State Significant Development Application – SSD 10321 – John Whiteway Dr, Gosford

Thank you for the opportunity to review the revised application for 89 John Whiteway Drive, Gosford. Please find below the response provided by the Central Coast Local Health District (the District), which has been collaboratively prepared by the District's Health Planning, Health Promotion and Public Health Services as well as NSW Ambulance.

Date: 4 June 2021

Figure 9 | Proposed public walkway and viewing platform (Base Source: Distinctive Living Design)

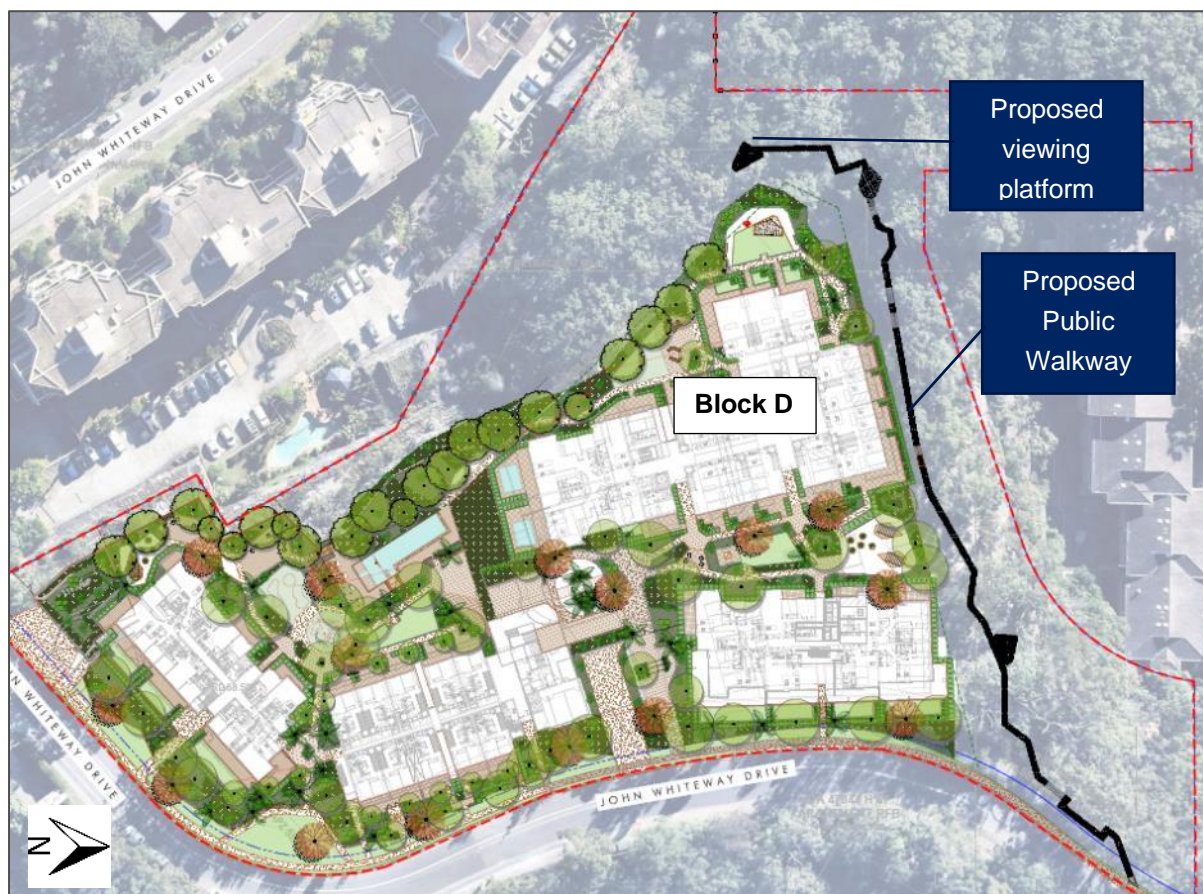
- EIS
 - 3.6 Landscaping and Public Domain
 - 3.6.1 Public Through Site Link and Viewing Platform – We commend the proponent's commitment to provide public pedestrian access through the site. To ensure this facility is truly accessible, we recommend adherence to best practice accessibility and Crime Prevention Through Environmental Design (CPTED) guidance is required as a condition of development consent. Refer also to comments regarding 5.7.3 Pedestrian Access.
